REQUEST

Current Zoning: N1-A (neighborhood 1-A), CG (general business)
Proposed Zoning: I-1(CD) (light industrial, conditional)

The petition proposes to allow the development of convenience store with gas and diesel fuel pumps along with accessory and incidental uses associated with the principal use. The site is currently undeveloped.

Staff recommends approval of this petition upon resolution of outstanding issues related to Transportation.

**SHEET TITLE:**

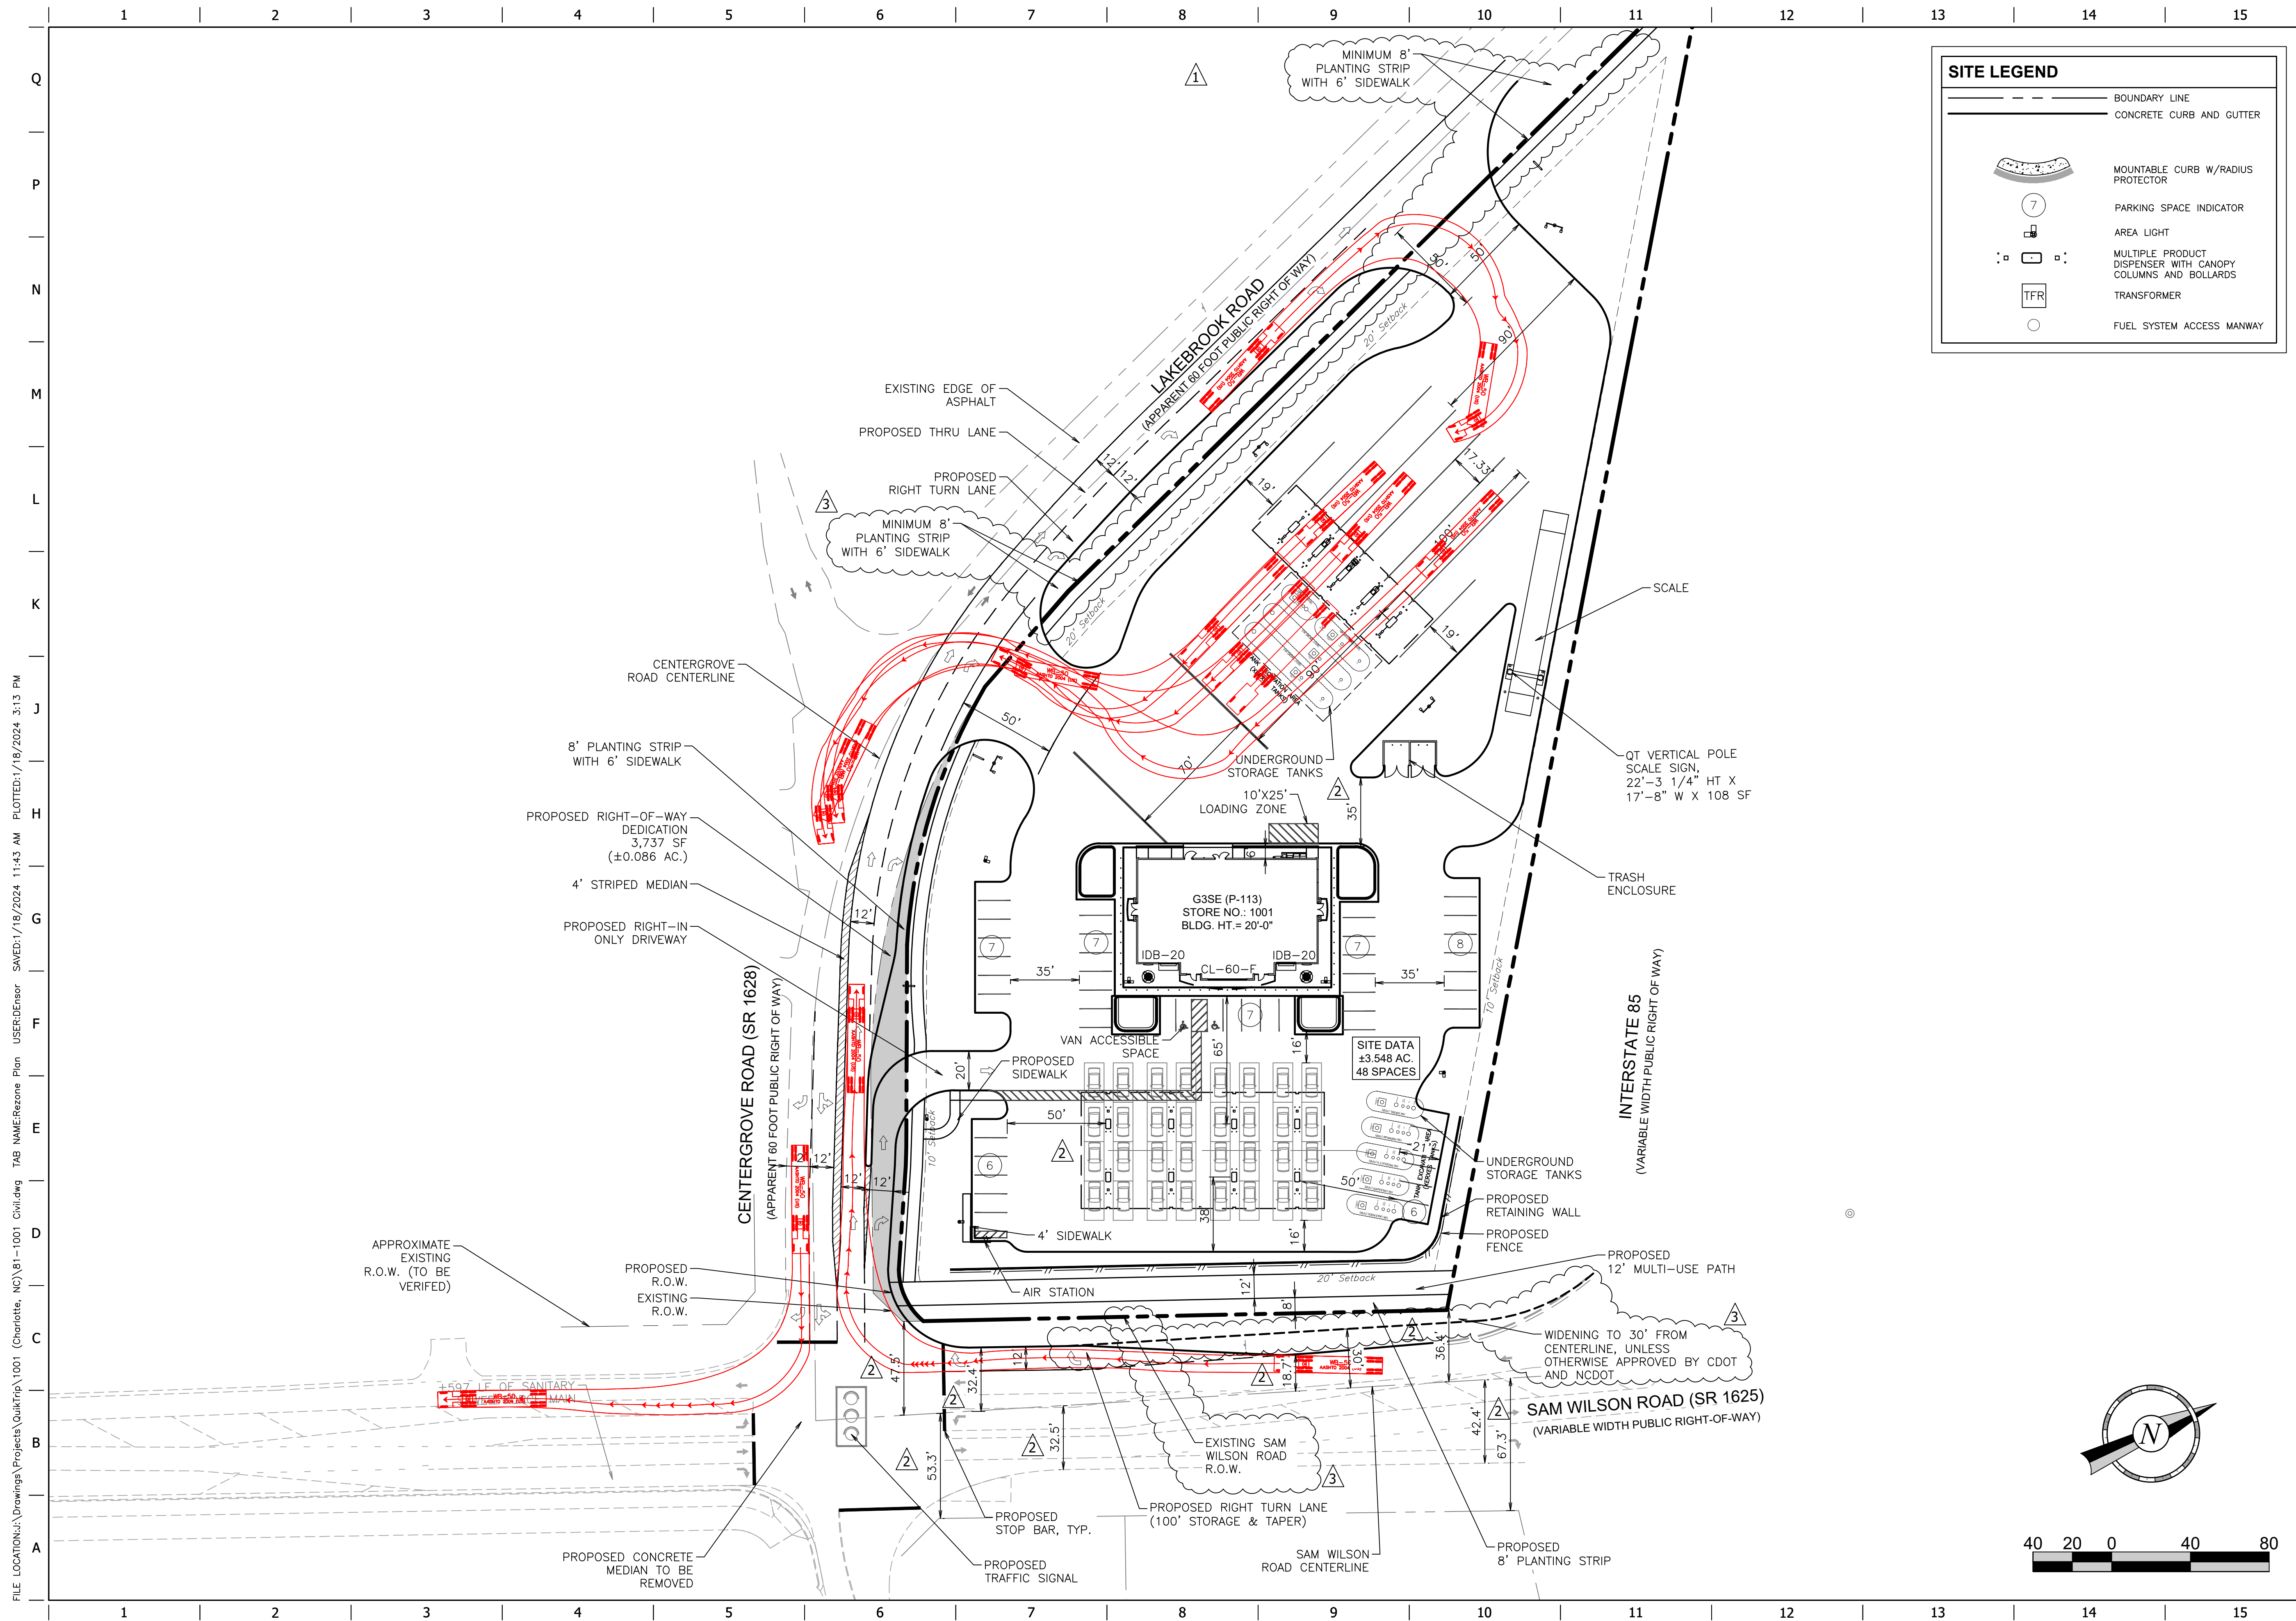
1. Location of curb and gutter to be moved to 30 feet from roadway centerline to accommodate the Charlotte Streets Map with a roadway typical section of a 4+ avenue with a 12-foot multi-use path. Label and dimension curb and gutter 30 feet from roadway centerline on Sam Wilson.

2. Revise site plan and conditional note(s) to commit to dedicate 35 feet of right-of-way from the road centerline on Sam Wilson Road. The site plan shall label and dimension the right-of-way from the road centerline. Label and dimension right-of-way from roadway centerline on Sam Wilson.

3. Revise site plan to clearly show and label where existing right of way is and proposed right of way.
4. Revise site plan and conditional note(s) to construct 8-foot planting strips and 6-foot sidewalks on Centergrove Lane and Lakebrook Road and a 12-foot multi-use path on Sam Wilson Road. The site plan shall label and dimension both items from the back of curb and gutter or edge of pavement. Add conditional note The entire facility must be outside of the right of way and within a public access easement. Add conditional note committing to construction and maintenance of the 6-foot sidewalk on Centergrove Lane and the 12-foot multi-use path on Sam Wilson Road. Add conditional committing to maintenance of 6-foot sidewalk on Centergrove Lane.
